ADC Planning Consultation Response from the Conservation Officer

Application Number	AW/159/13
Address	78 Barrack Lane, Bognor Regis
Description	New Detached Double Garage
Case Officer	Mrs. J Chapman

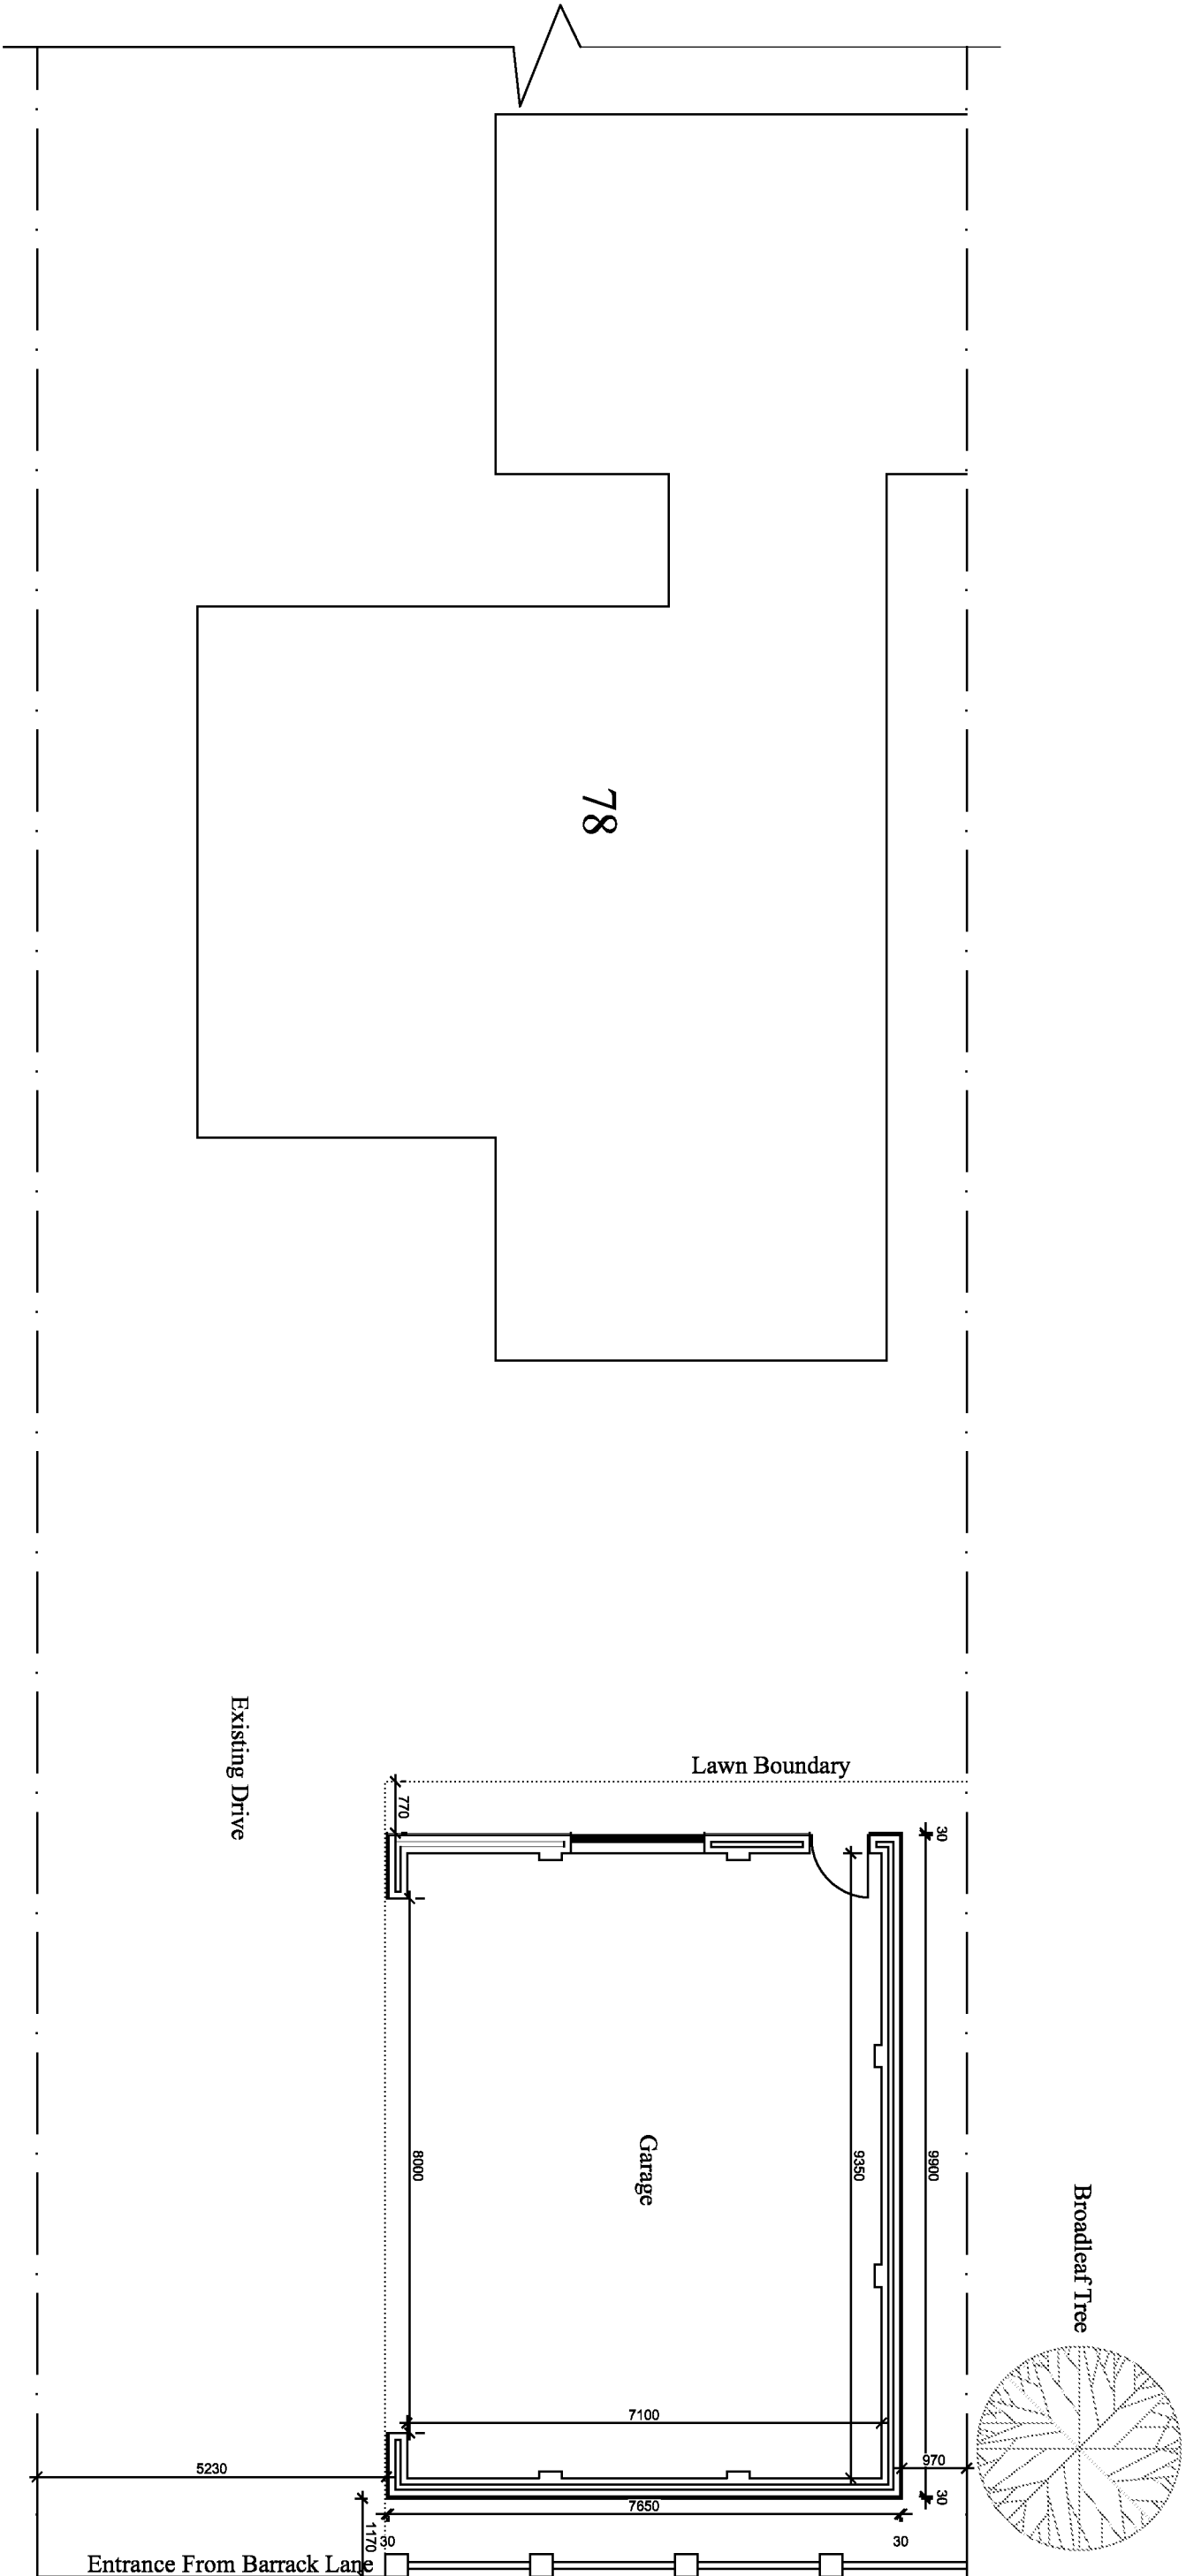
The proposal is for a substantial garage in the front garden of the property. This would be located forward of the established building line. Further, the garage would accommodate a substantial amount of the front garden; this is in conflict with neighbouring properties where gardens are laid to lawn or hard standing.

Further, I have also noticed that the garage is located very close to a neighbouring tree. The tree is of high visual street amenity and should be preserved.

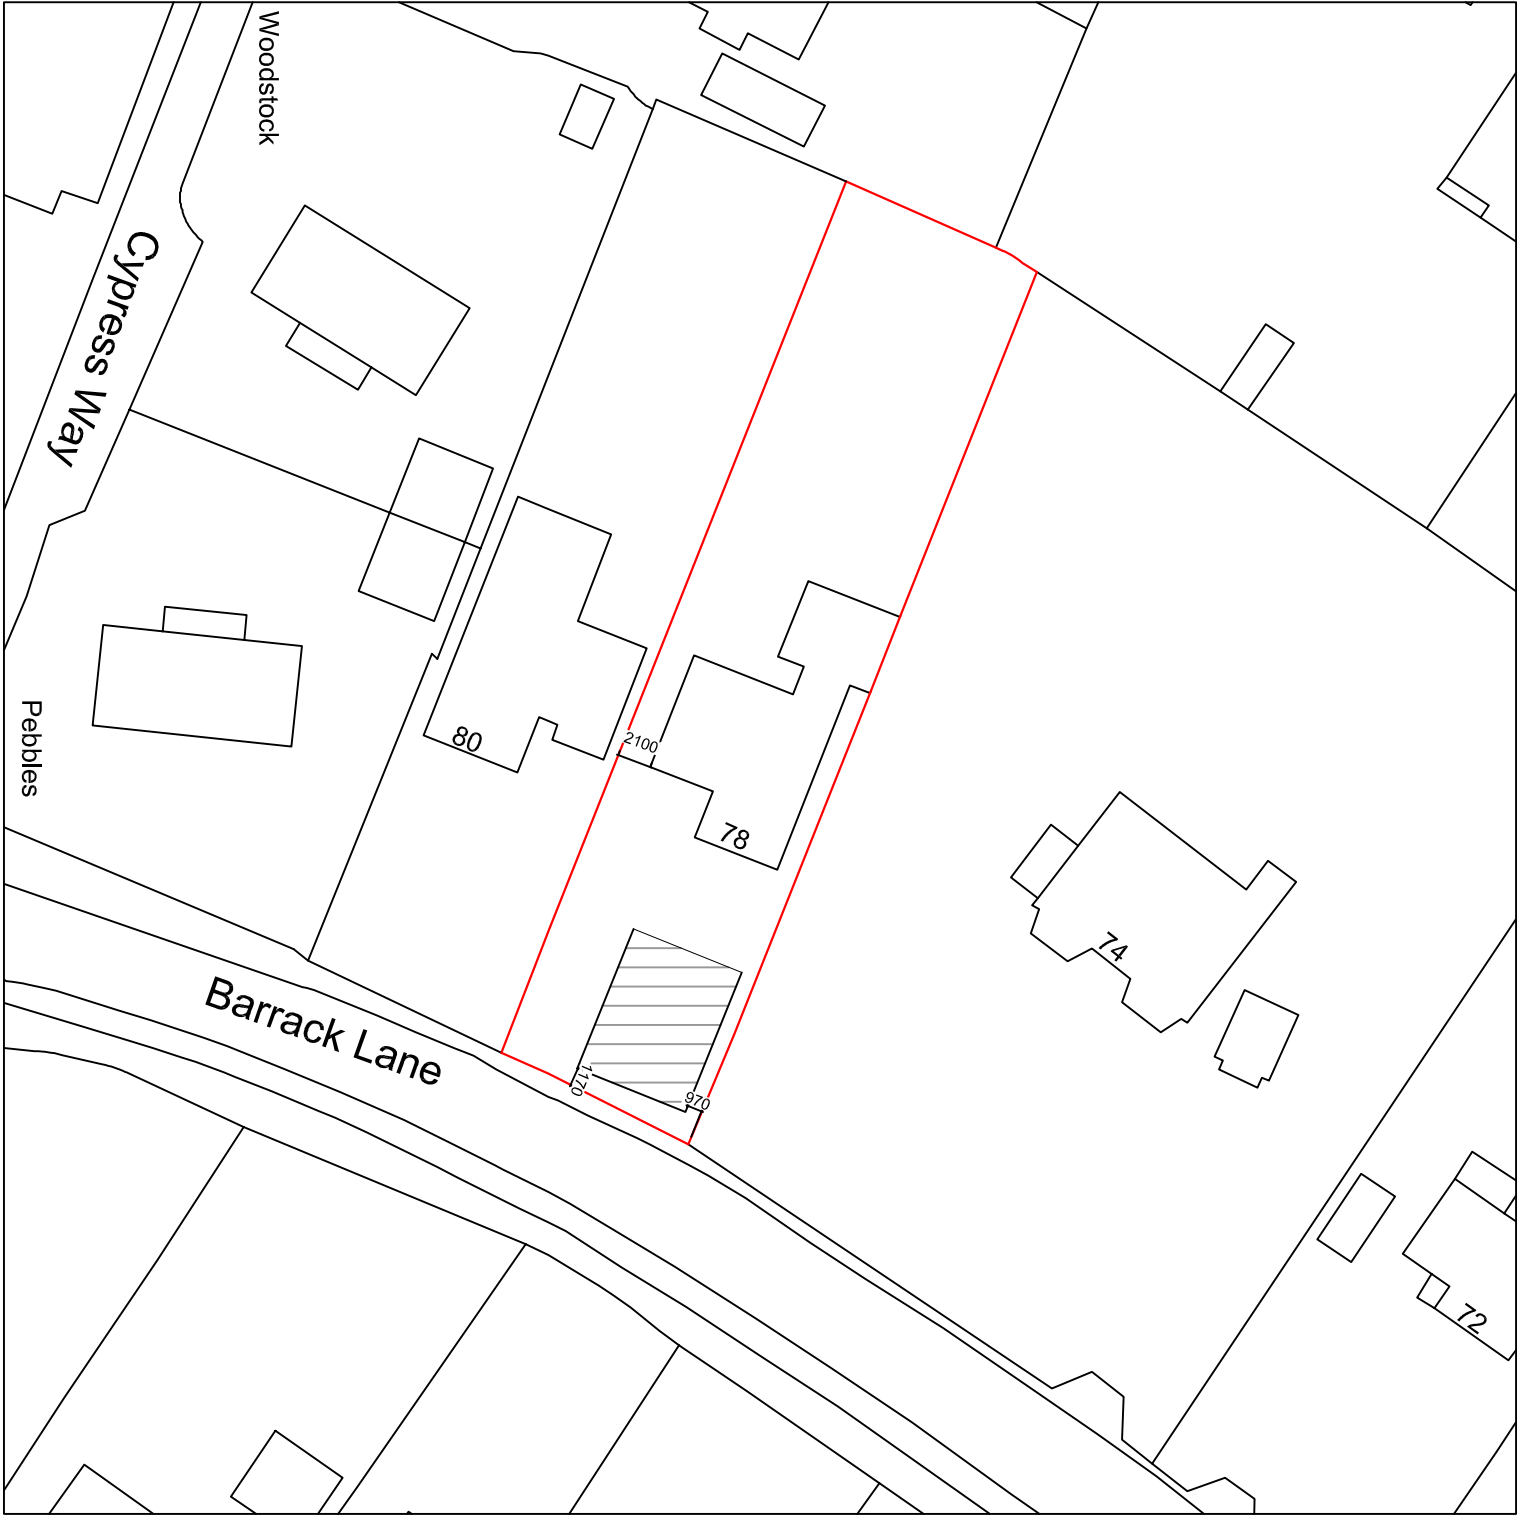
It is therefore considered that the proposal would conflict with the established character and pattern of the site or the locality and result in an uncharacteristic form of development along the established street-scene.
